CITY OF ALBUQUERQUE

RE: Wellesley Apartments
208 Wellesley Dr SE
Grading and Drainage Plans
Engineer's Stamp Date: 6/12/25
Hydrology File: K16D097
Case # HYDR-2025-00214

Based upon the information provided in your submittal received 06/13/2025, the Grading & Drainage Plan is **not** approved for Grading Permit or Building Permit. The following comments need to be addressed for approval of the above referenced project:

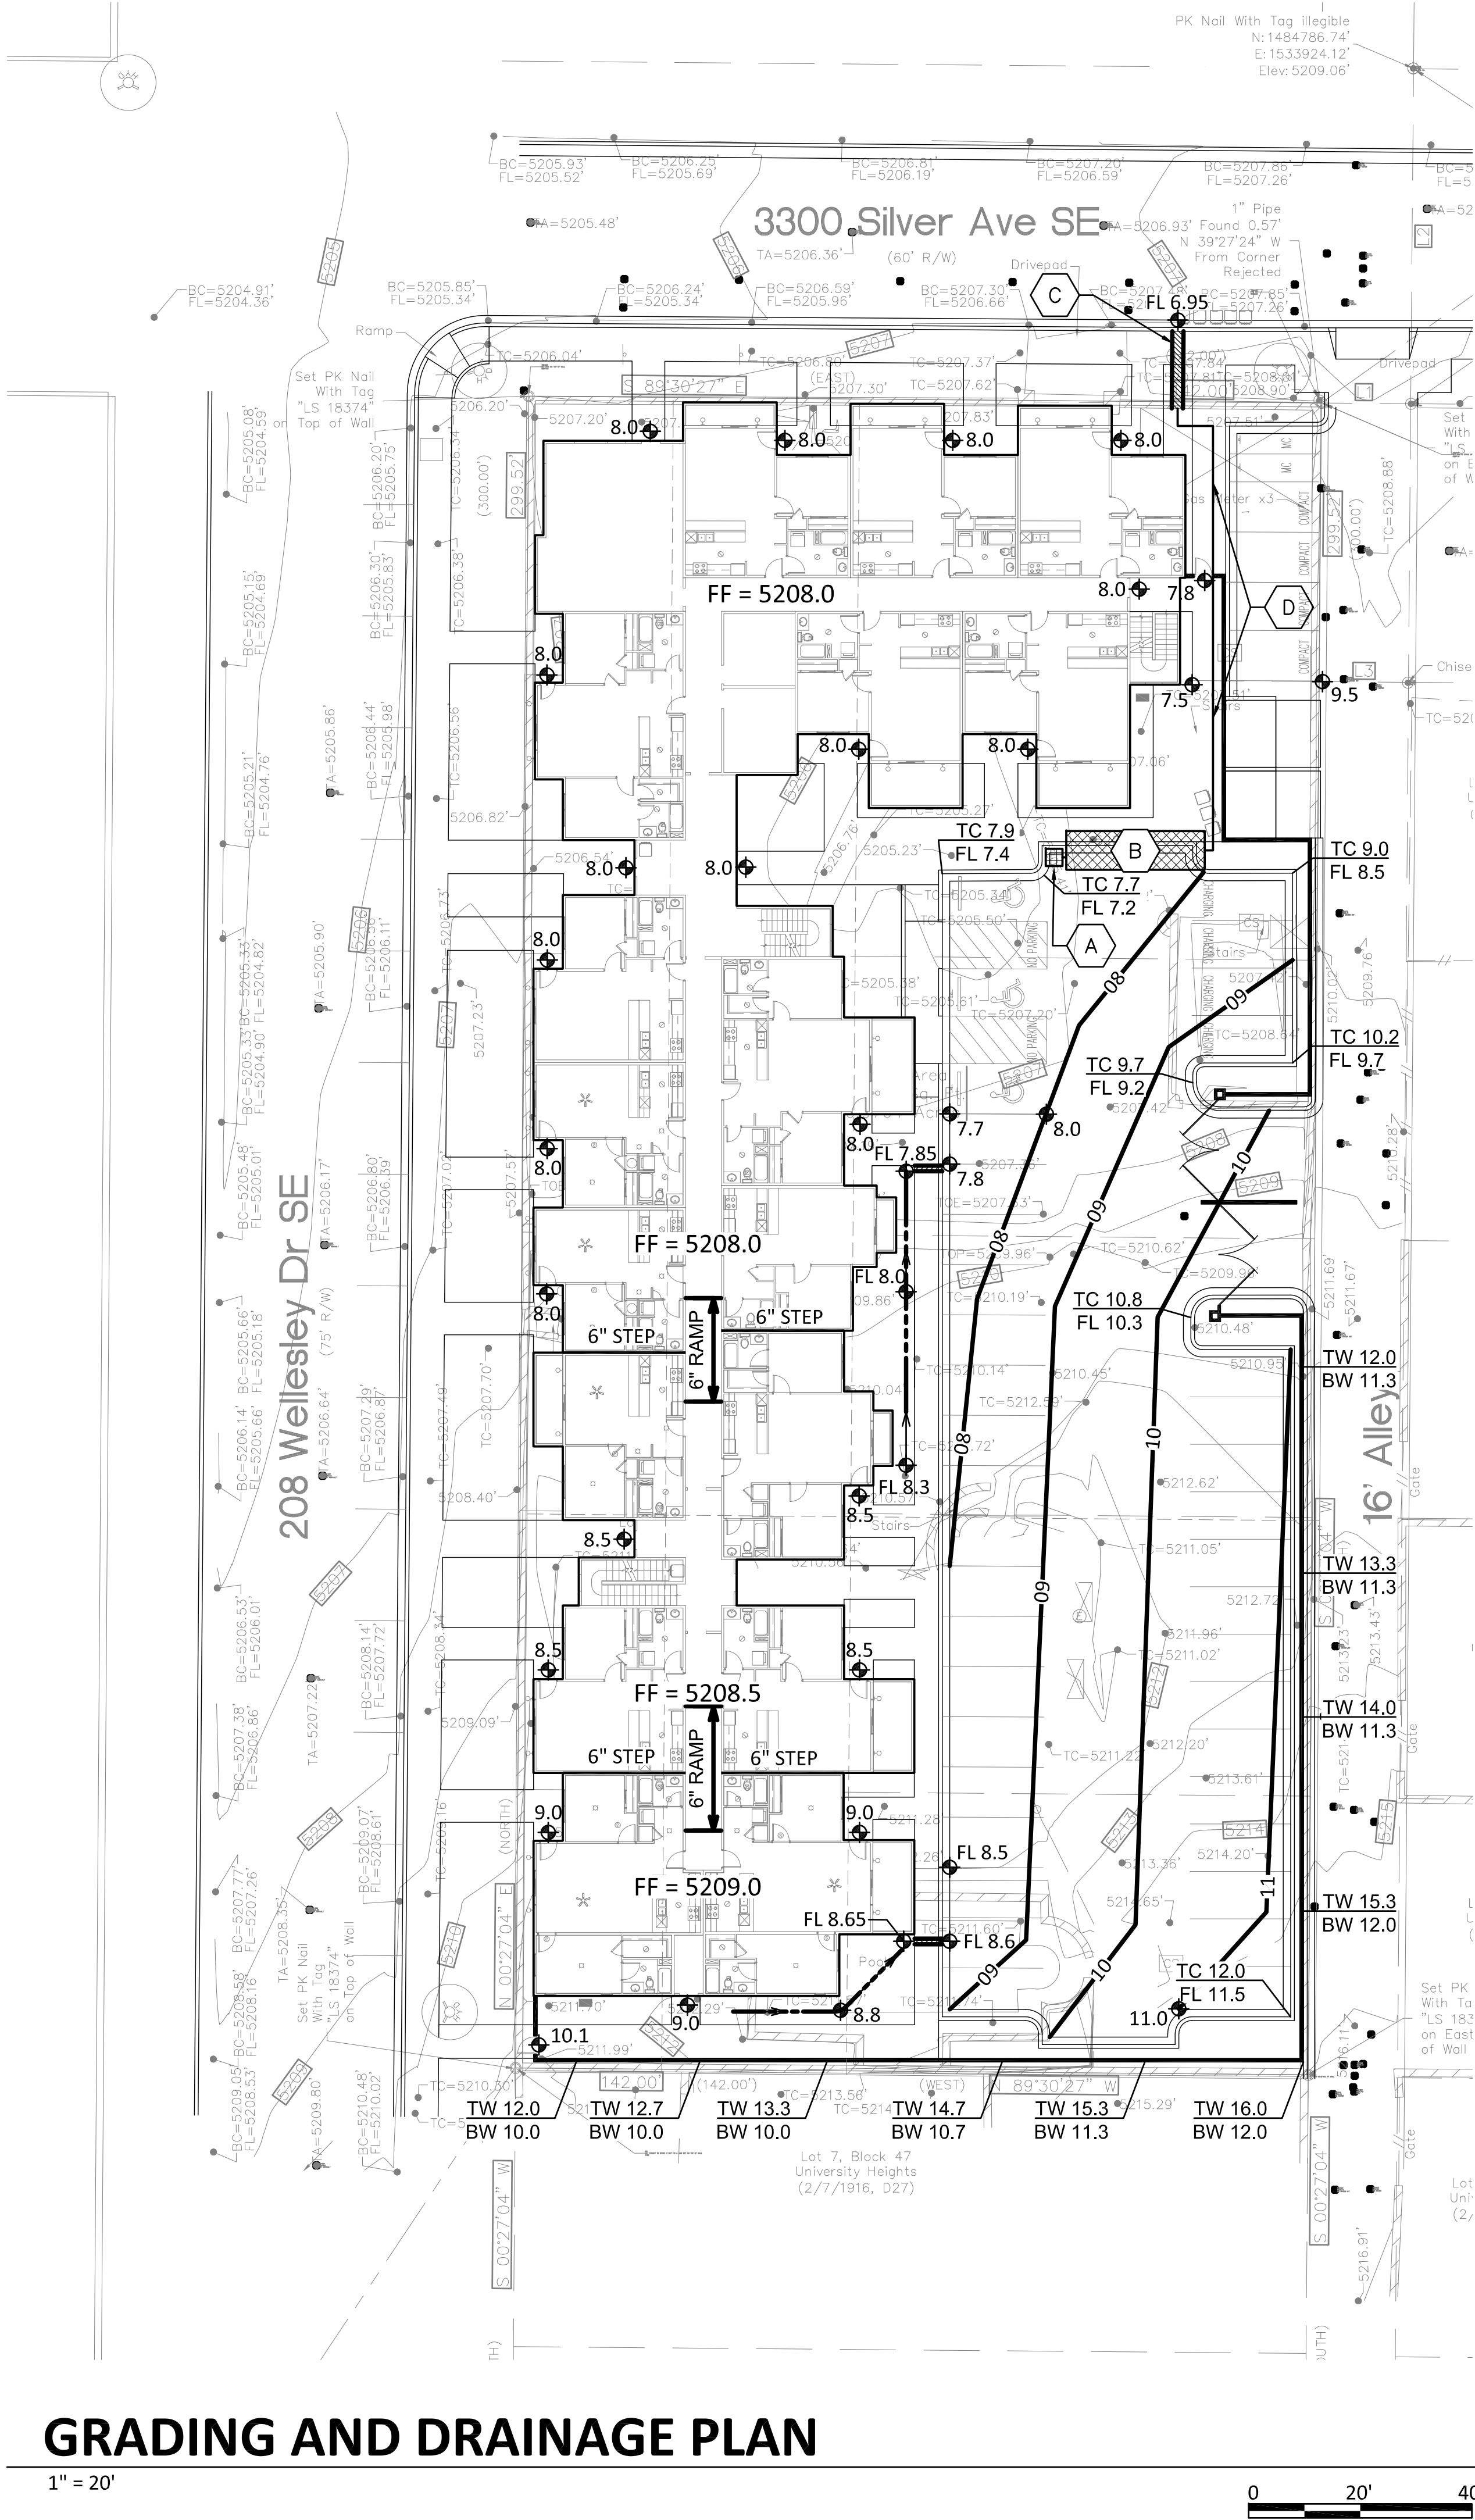
1. Please provide the FIRM Map and floodplain note with effective date.
2. An SO-19 Permit will be required and should be included on the request. Please include the [standard SO-19](#) notes on the grading plan.
